REPORT UPDATE

Application No: R/181/15/PL

Recommendation Report for Planning Permission**REF NO:** R/181/15/PL**LOCATION:** Land to the south of The Tiled Barn
Station Road
East Preston**PROPOSAL:** Erection of 2 No. 3 bed dwellings, demolition of existing garage & shed & erection of new car port. Resubmission following R/305/14/PL. This application affects the character & appearance of the Station Road Conservation Area.**SITE AND SURROUNDINGS**

Drawing title: Tree Constraints Plan

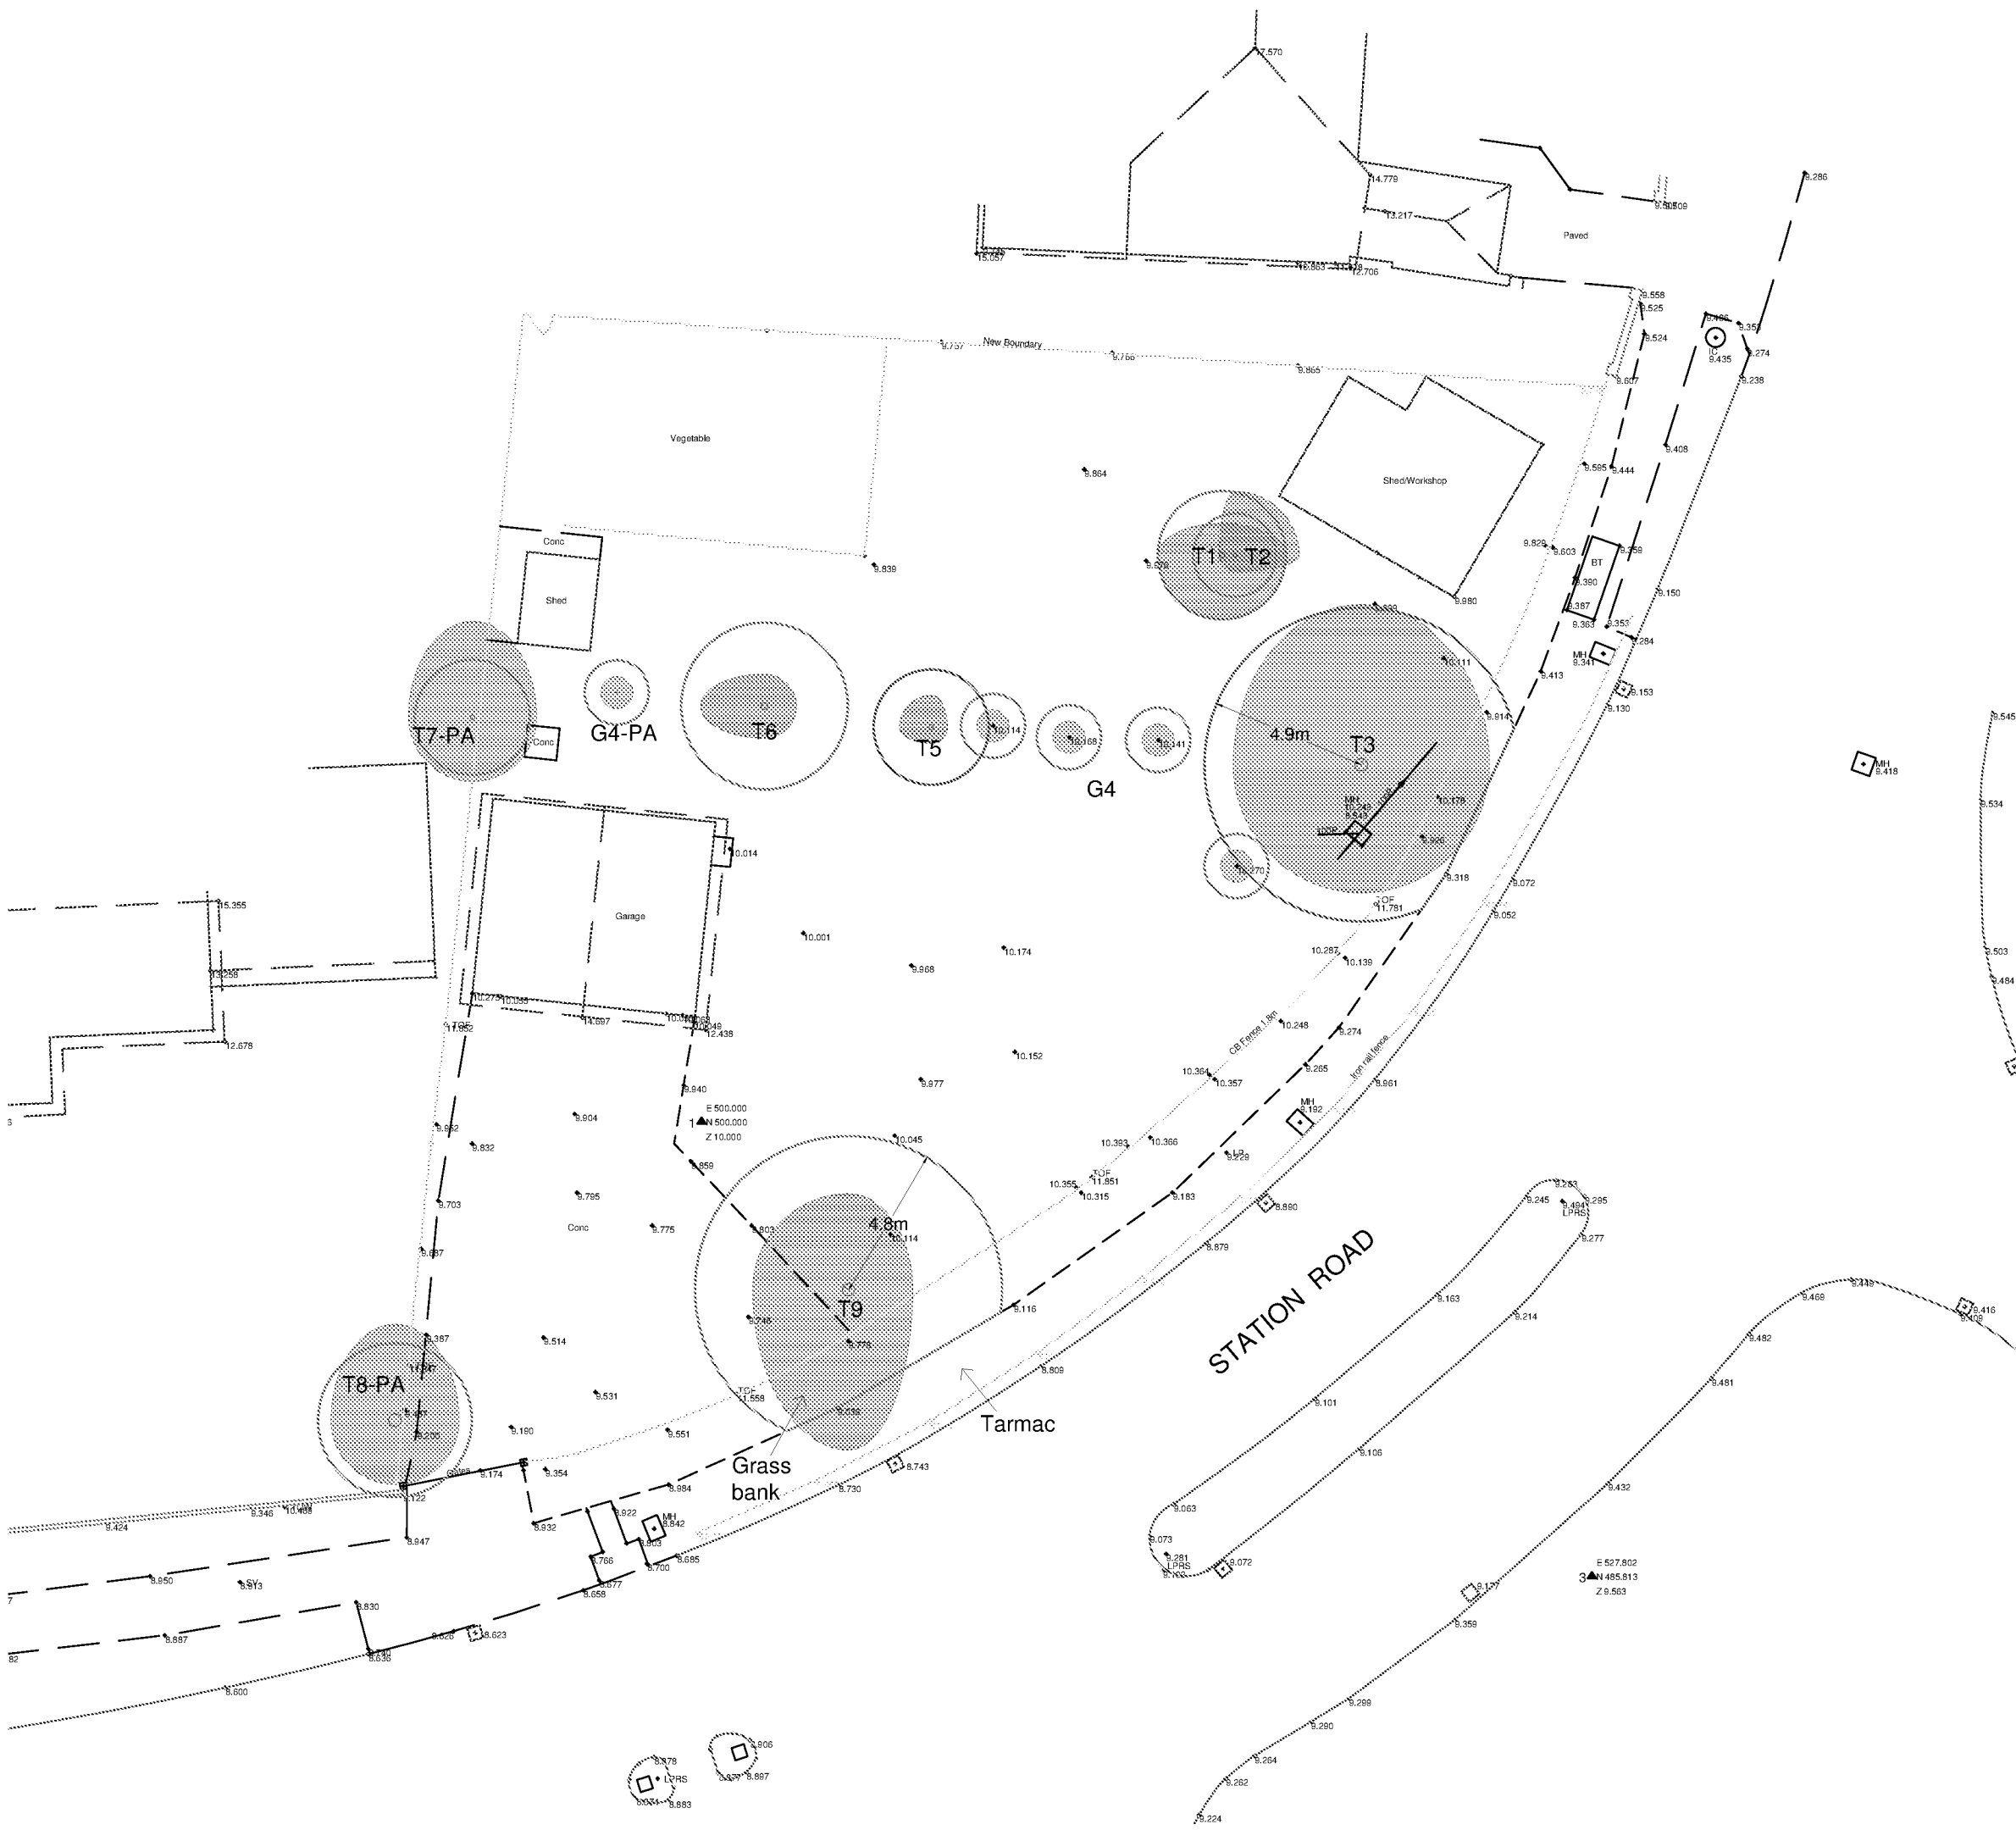
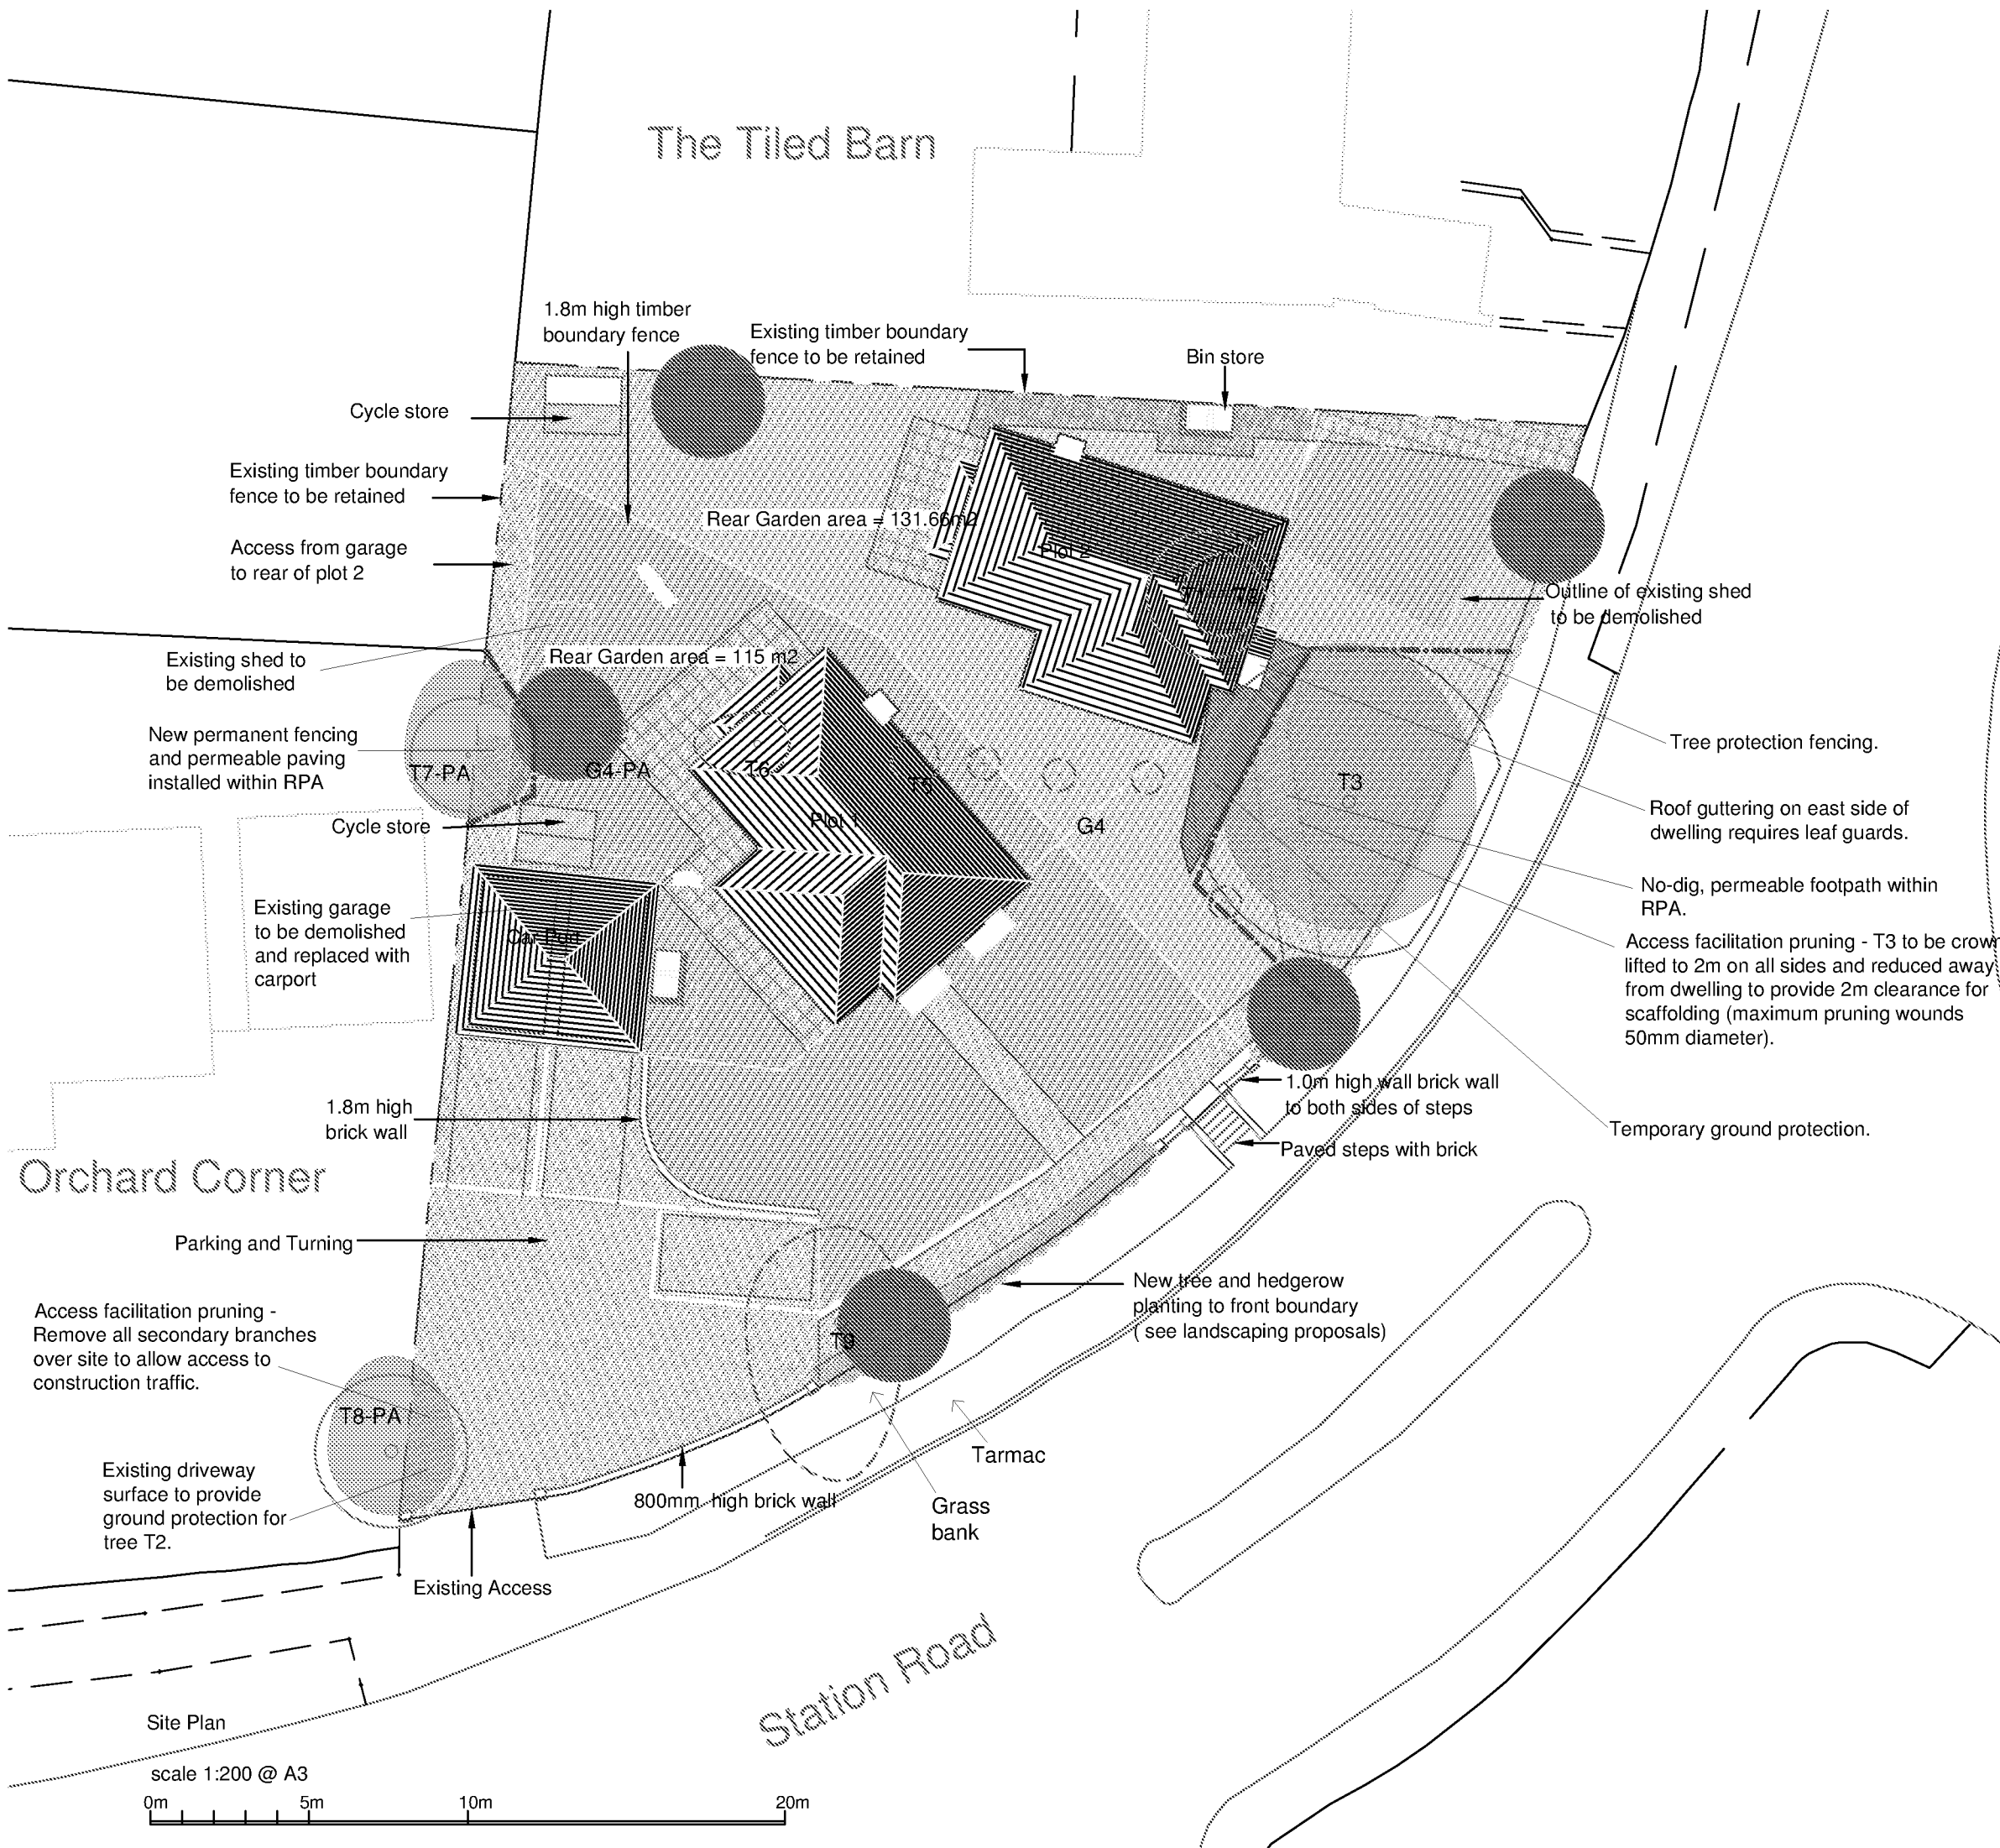
The application has outlined the desire to fell T1, T2, G4, T5, T6 and T9. I would object to the felling to the felling of T9, as I believe it has the attributes to warrant a TPO order. No objection to the felling of T1, T2, G4, T5, and T6.

No objections to the hard surfacing encroaching T3 by 16.3% and T7 by 34.1%, as the applicant has stated the surfacing material must be a geotextile membrane.

No objection to the proposed crown lift of 2 meters, and the lateral reduction of no more than 1 meters to T3, as it is unlikely to have any lasting negative impact to T3.

If T9 is retained under TPO, alterations would have to be made to the submitted application to ensure damage is not inflicted. This would include suitable RPA/tree protection for the duration of the construction process. Also alterations are likely to have be made membranes/surfacing to the west of T9, where the proposed parking and turning area is due to be placed, as this area is likely to overlap with the RPA of T9.

Comments noted. Requested conditions have been imposed. Tree T9 is now the subject of a provisional Tree Preservation Order.
